Date: 15-Feb-2024
Our Ref: 2023/93794

**Application for Approval of Details Reserved by Condition
Town and Country Planning Act 1990
Planning (Listed Buildings and Conservation Areas) Act 1990**

**Dishcharge conditions 4 (materials), 6 (boundary treatments), 9 (bat box), 10 (retaining walls), 11 (structural dilapidation survey), 12 (slope stability analysis of embankment) on previous permission 2023/91195 for erection of two semi-detached dwellings with integral garaging and associated external works
Land Adj to 80, Greenhill Bank Road, Holmfirth, New Mill, HD9 1ER
Application Number: 2023/93794**

NORTH EAST ELEVATION

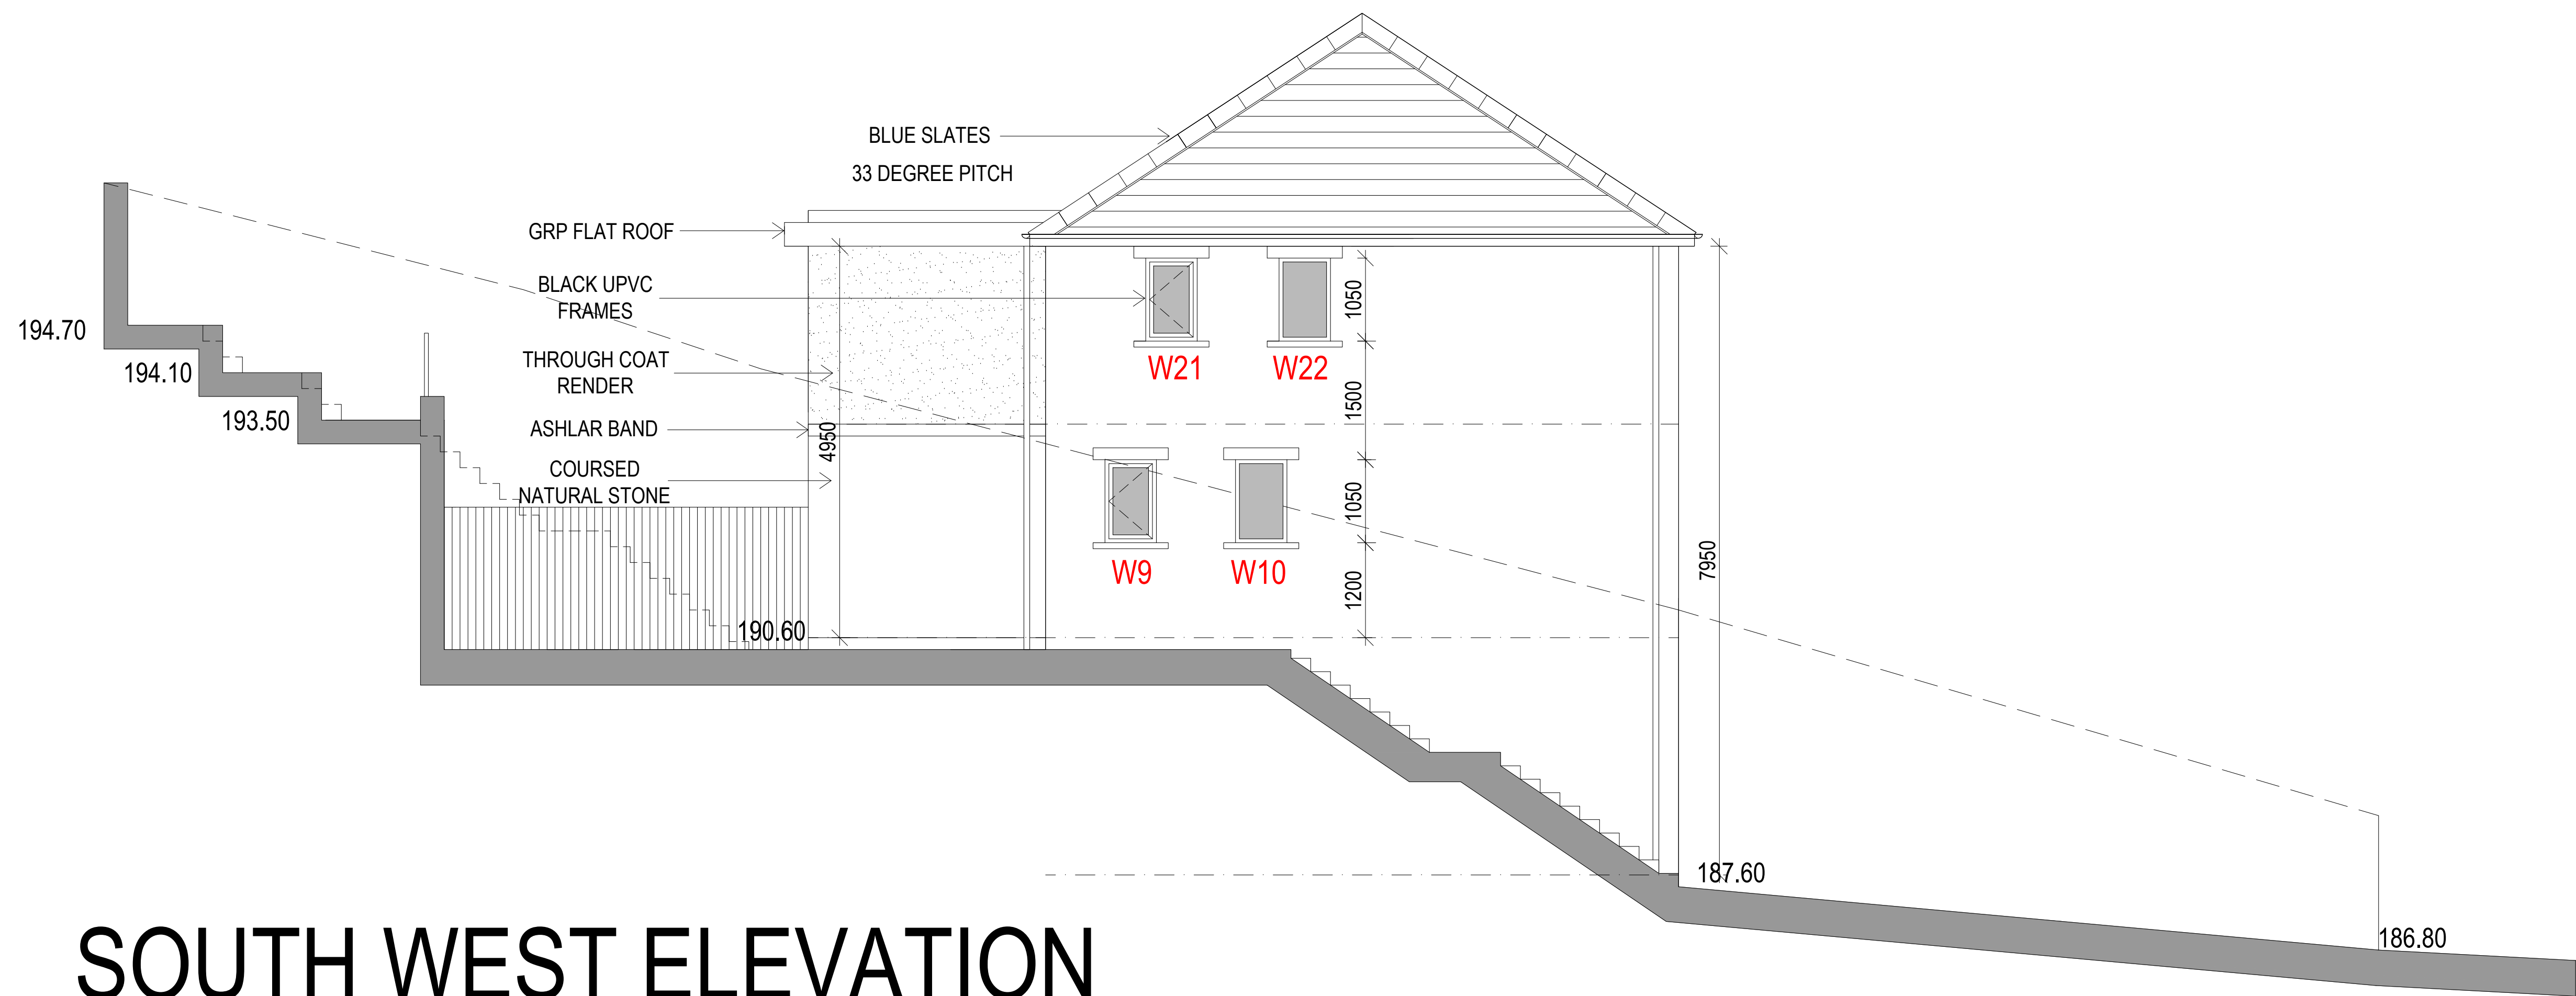
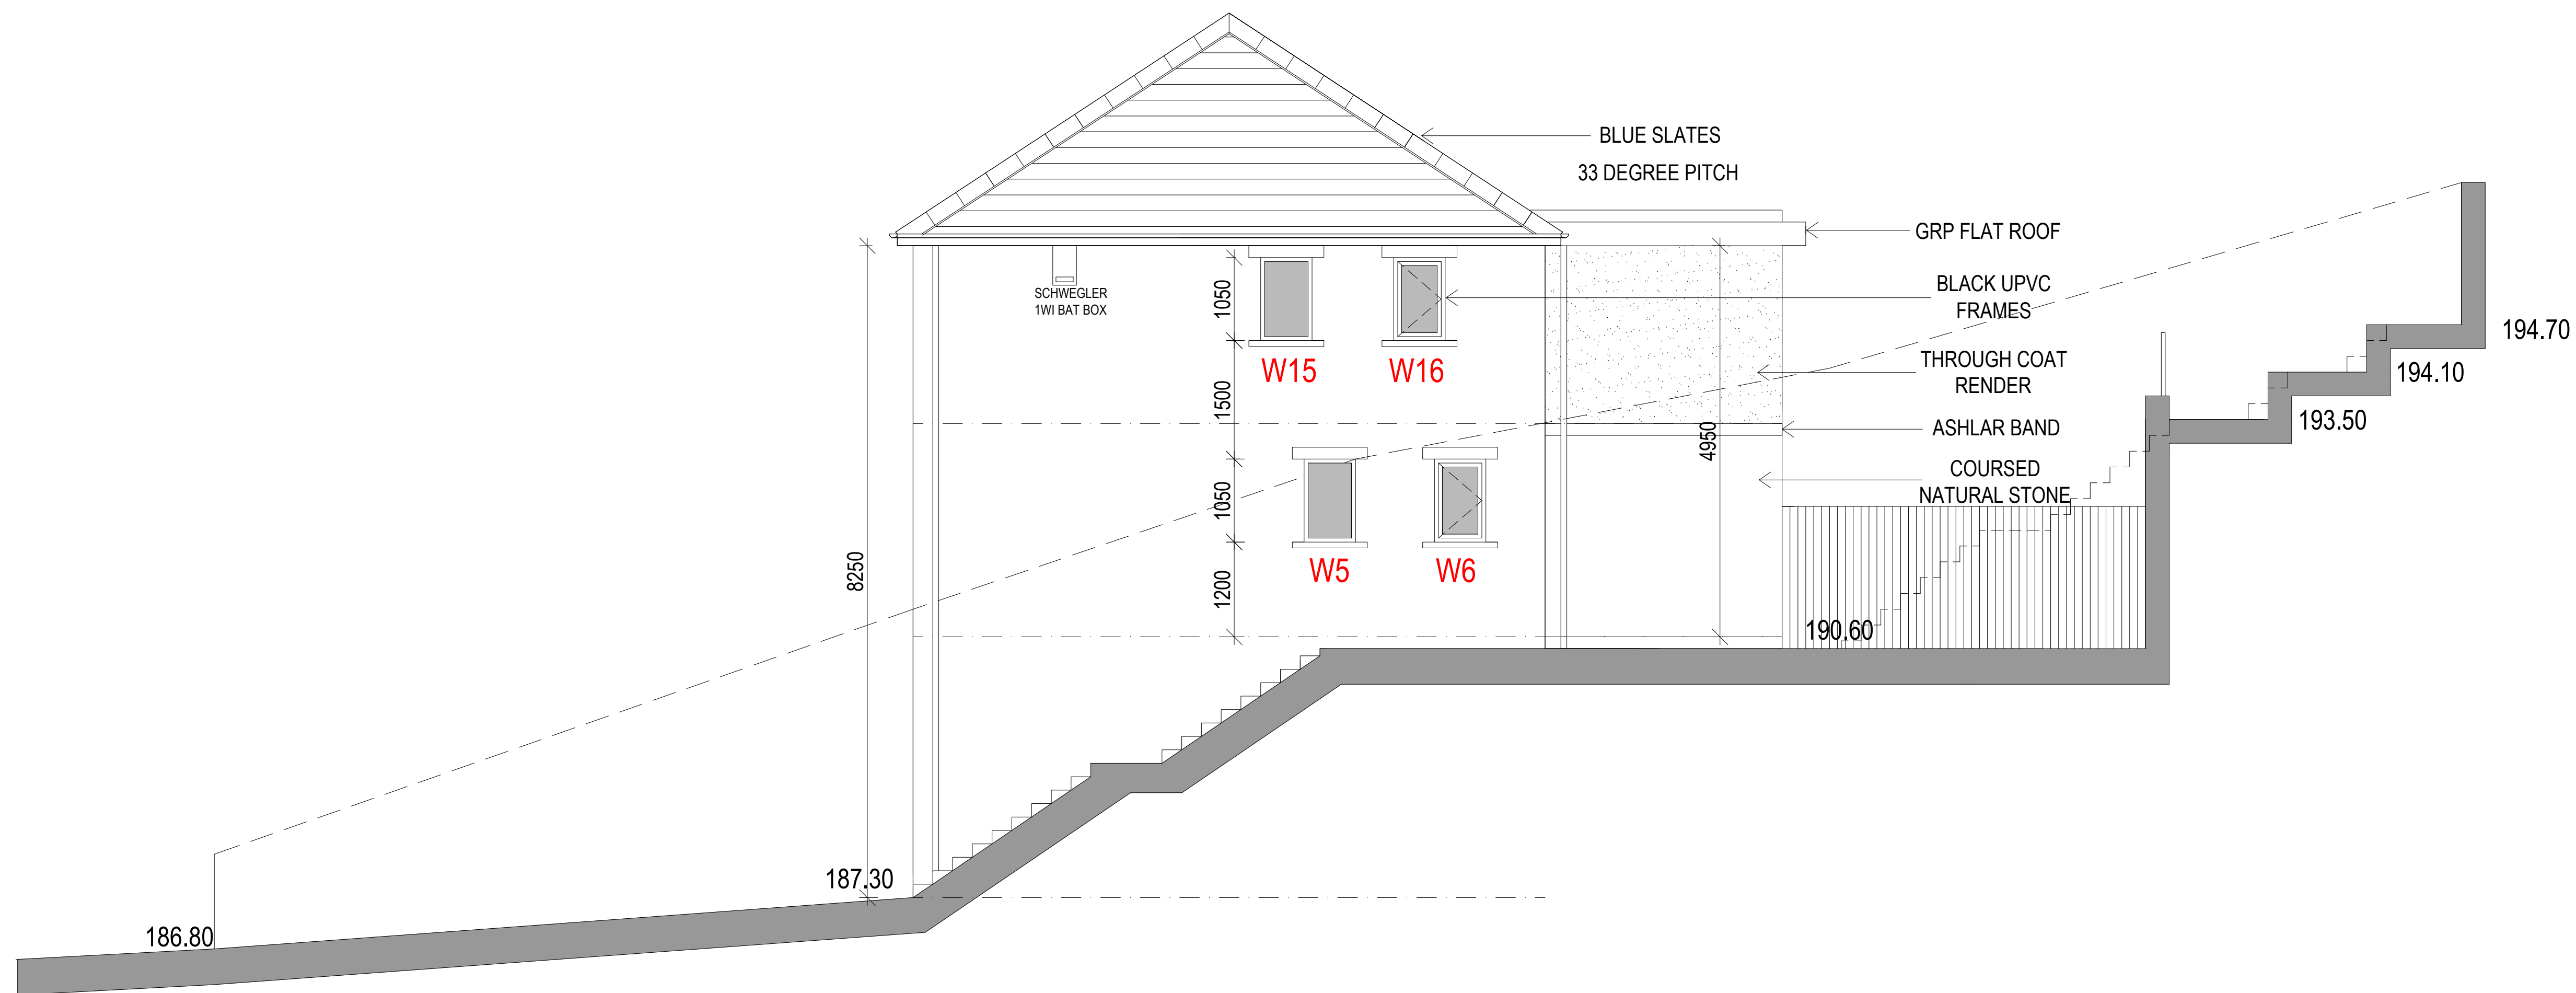
You have submitted a scheme to discharge this condition, set out in submitted drawing 02revC which details that a Schwegler 1wi bat box would be located at the eaves level of the north eastern elevation of the pair of dwellings. The positioning and location of the bat box is acceptable.
